Response to Submissions re 85 Harrington Street Development Application						
Date of Issue: Wednesday, 18 October 2017						
Source	Item	Issue/Object	Description	ADG Objective	Drawing Number(s)	FJMT Responses
DoPE Letter Attachment A	1.1	Visual Privacy	Balconies serving units on Northern side of Building 2 have been reorientated towards Rendezvous Hotel. Provide a specific plan illustrating the varying setbacks between the two buildings, location of facing windows and balconies and proposed design measures to mitigate potential privacy impacts.	N/A	002 - 003	Solid, operable shutters, or horizontal metallic blinds that are controlled by the occupants of the unit are employed to provide privacy towards the subject site. The windows of question within the rendezvous hotel are fixed, have dark glass and the rooms are itinerantly occupied. Any potential privacy issues have been mitigated through a considered design response. Complies? Yes

85 Harrington Street
The Rocks
GOLDEN AGE & HANNAS THE ROCKS

TITLE
RESPONSE TO DoPE
Responses to Items

View from East Circular Quay
(Typical View Cone of Eye)

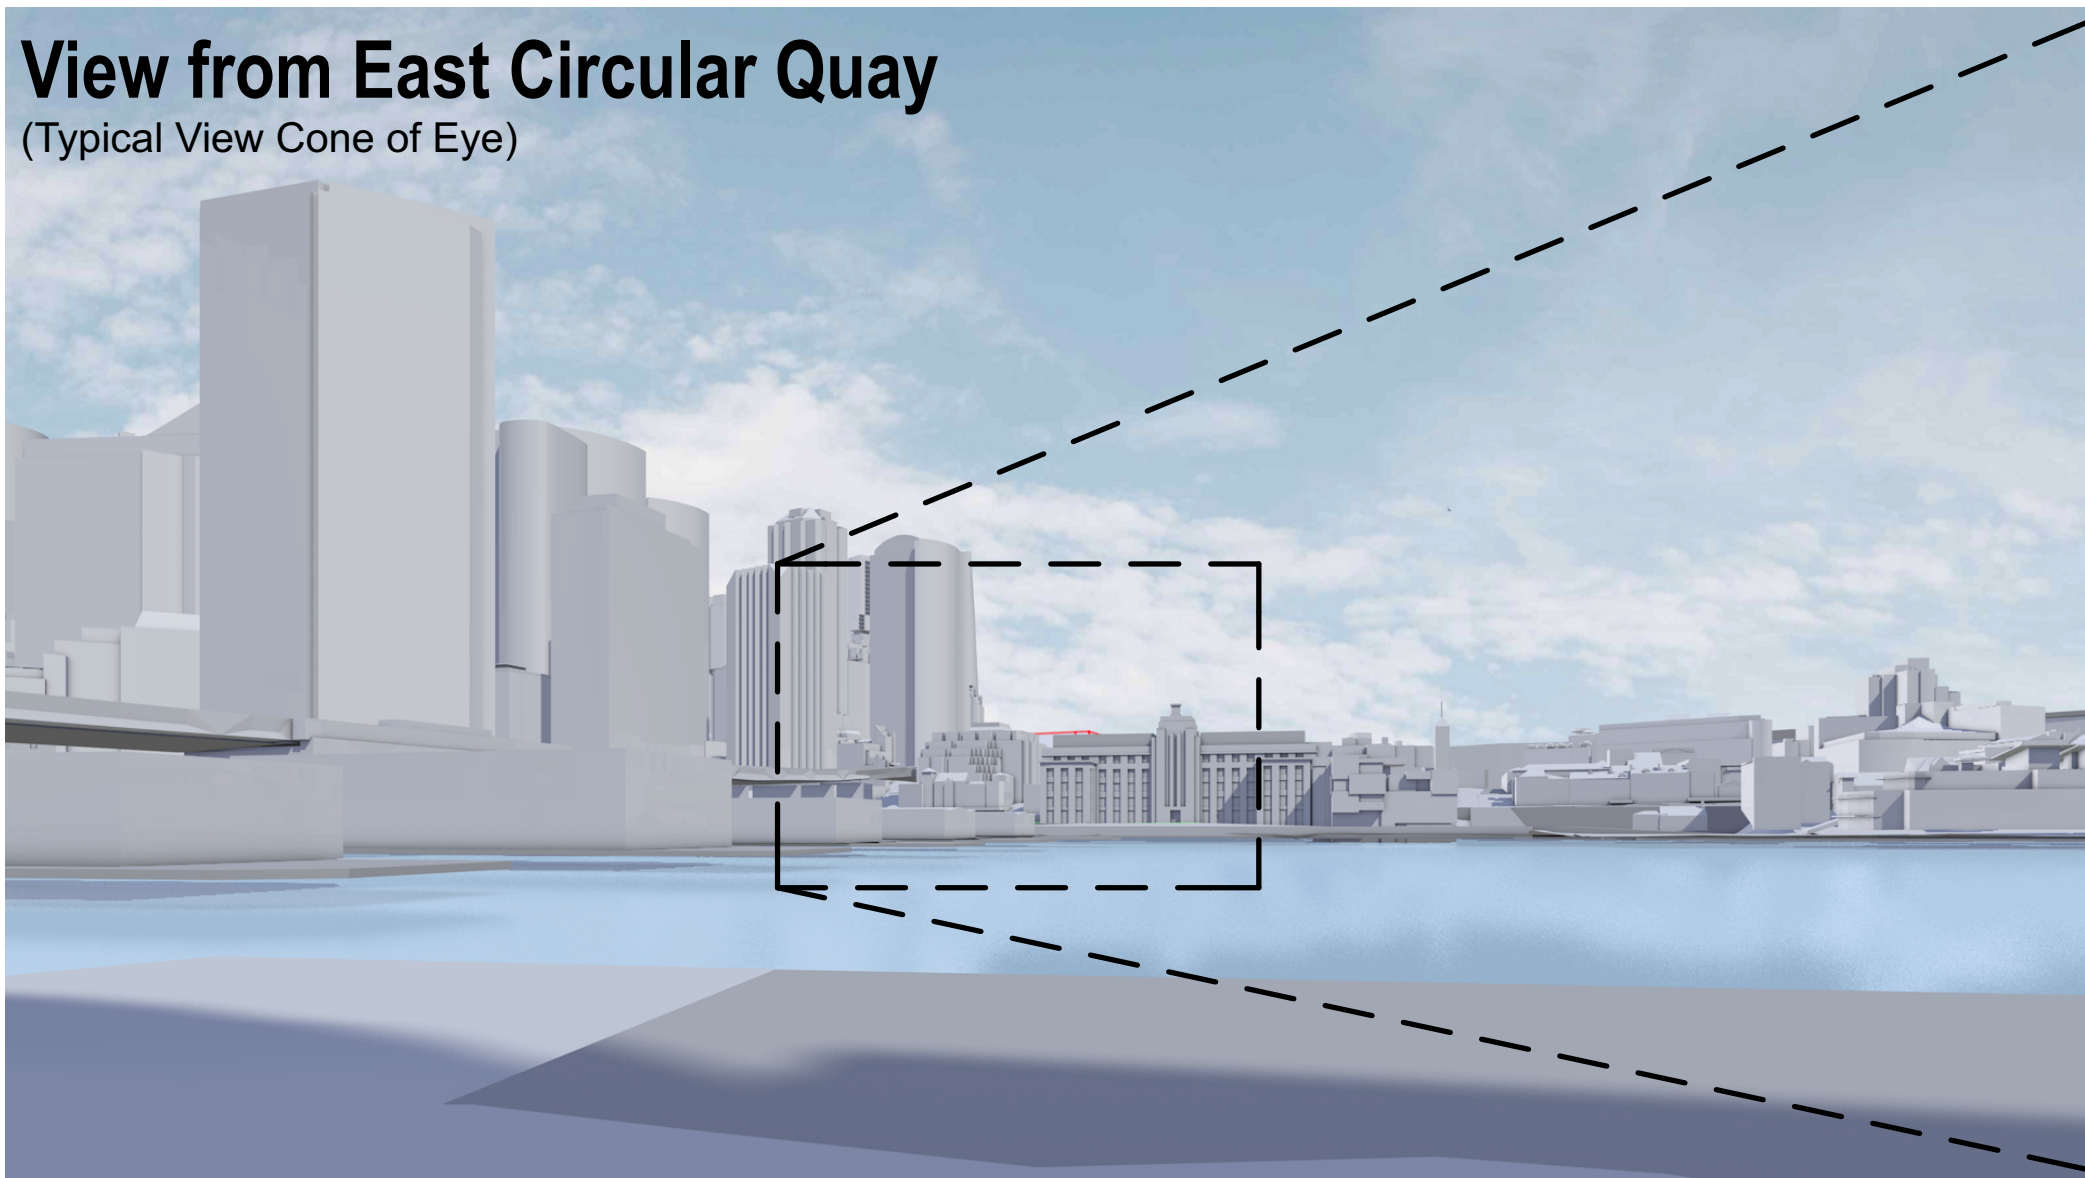
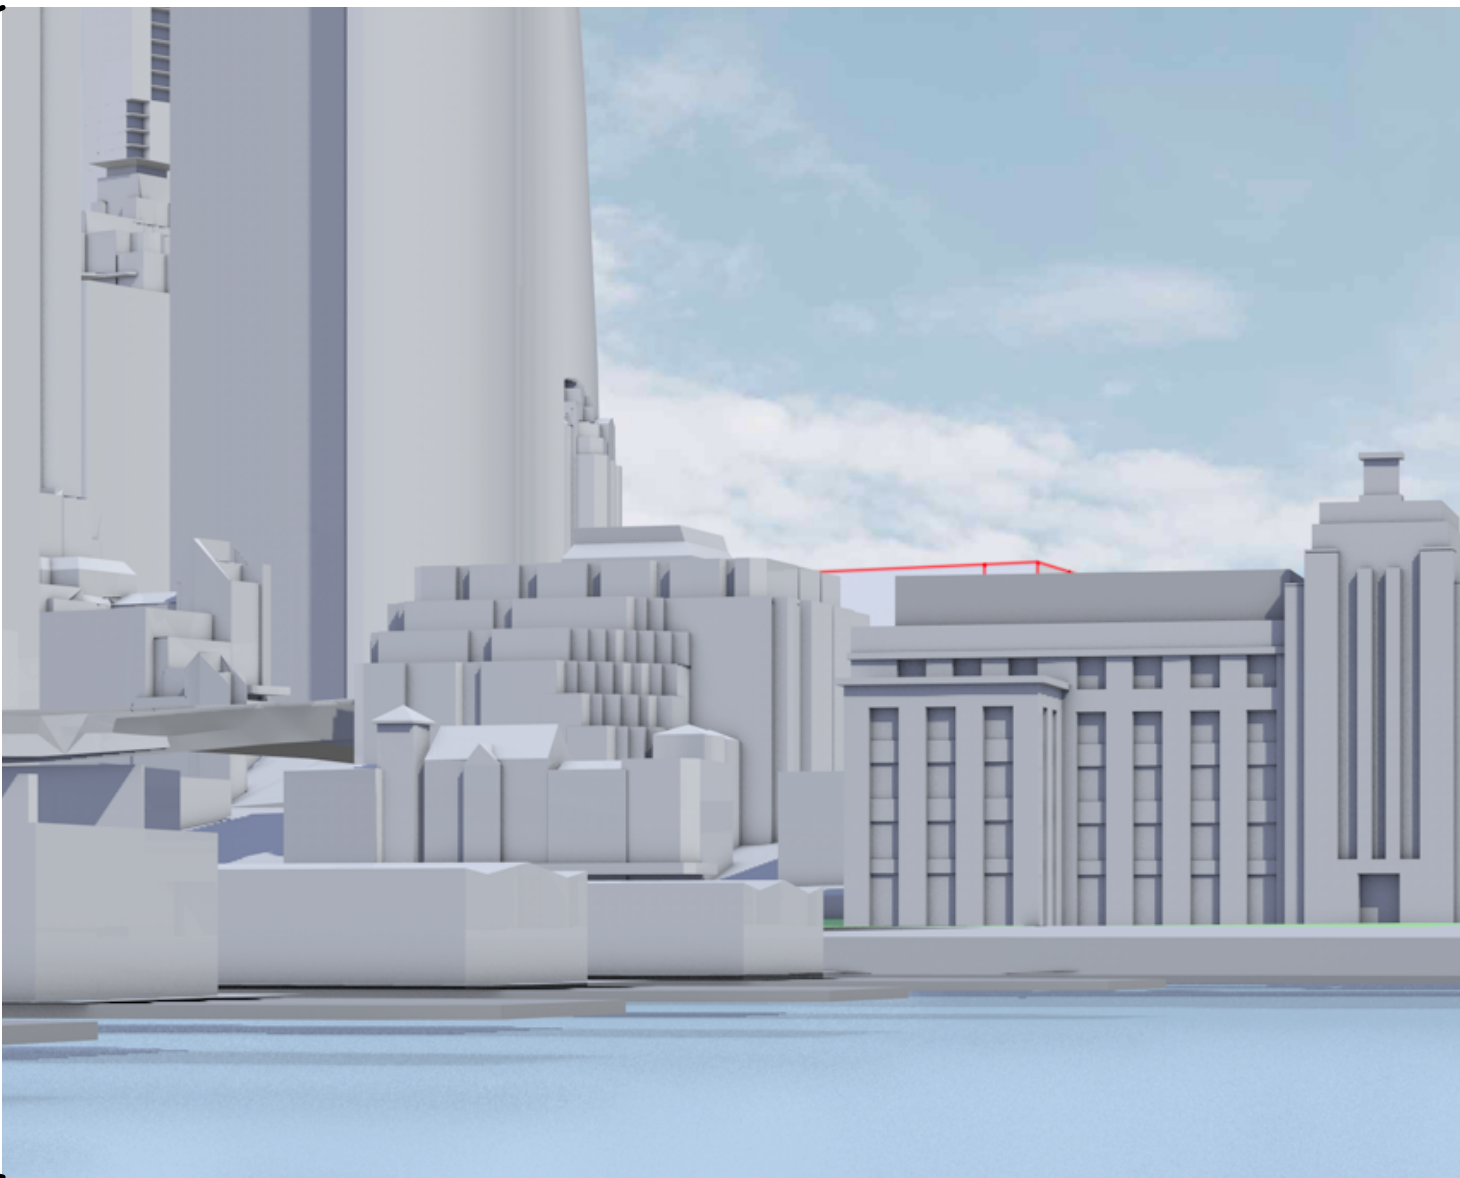
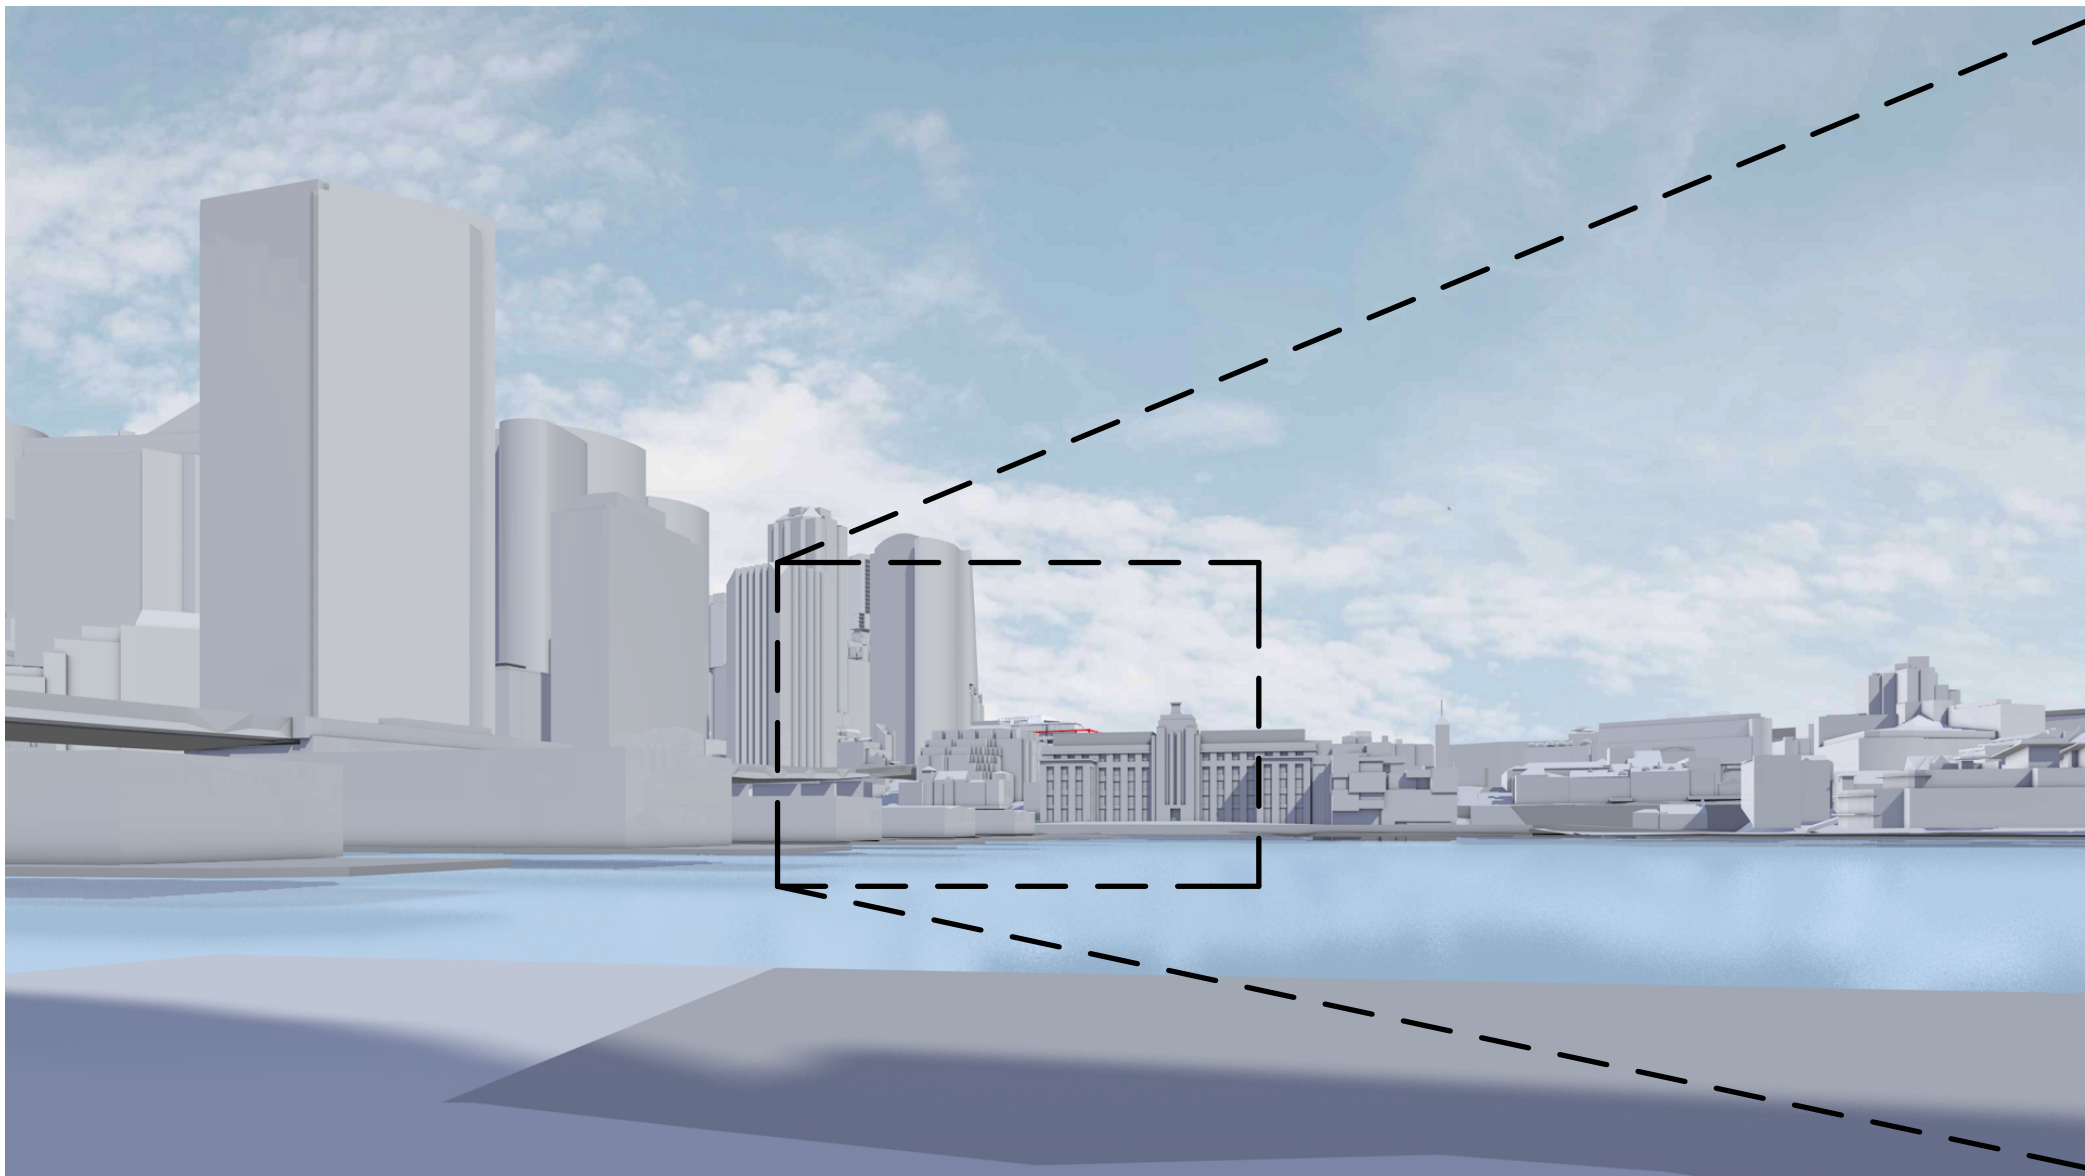
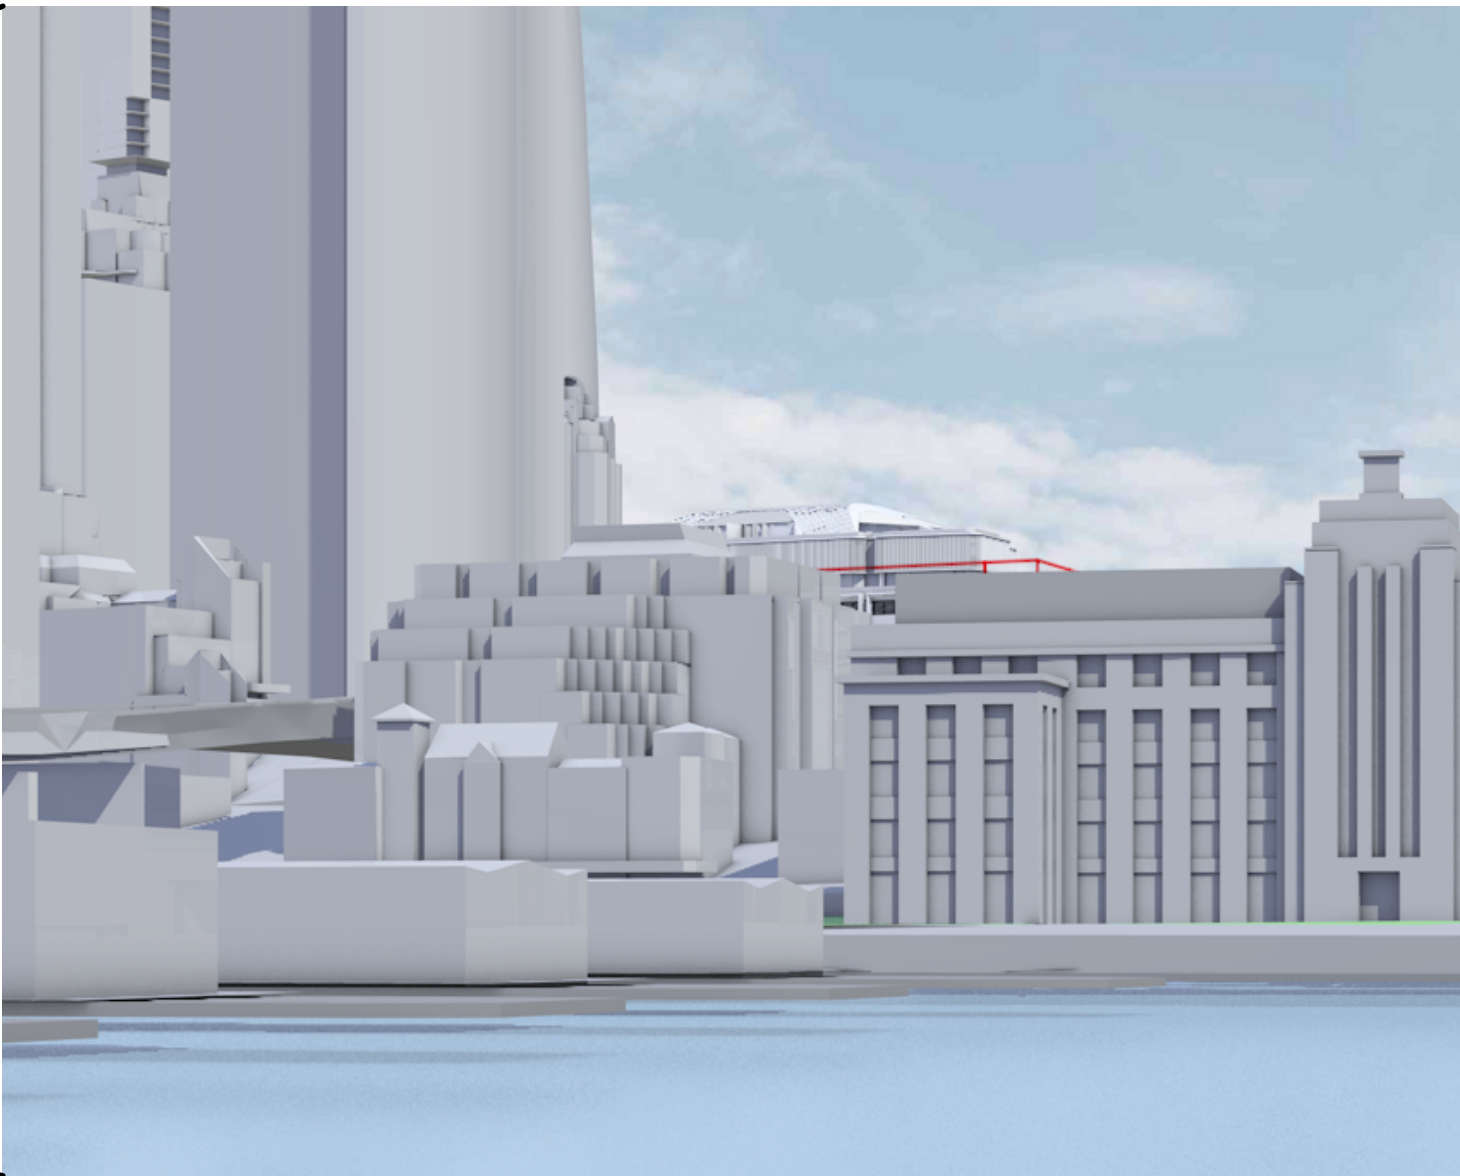
3.1	Views	Potential adverse impact on iconic views has been raised in a public submission. Please provide a view impact analysis demonstrating the potential impact of the proposed development (including plans) on identified views from 140-142 Cumberland Street and other nearby properties as relevant.		026	A view analysis has been undertaken for 140-142 Cumberland street. The objection from the owners of this property deals solely with loss of view towards the opera house (only). The analysis found that a large deciduous tree remains the biggest threat to view loss. Water views are largely unimpeded, nor reduced as a result of the development. Views toward the opera house have the potential to be increased as the proposed built form is less than that of the existing fabric. The analysis concludes that the objection is largely unfounded and views towards the opera house remain largely intact. Complies? Yes

3.2		Please provide revised and enlarged images illustrating view impacts from a SCRA compliant scheme and separate comparison images illustrating views impacts from the proposed scheme. Please also state the RL/level within the building the views are taken from and whether views from permanent residential units within Quay West are potentially impacted by the proposed development.		027 - 032	Updated diagrams showing impacts from a SCRA compliant scheme and the proposed development been provided. The images have been enlarged and RLs provided for each of the view diagrams. Complies? Yes
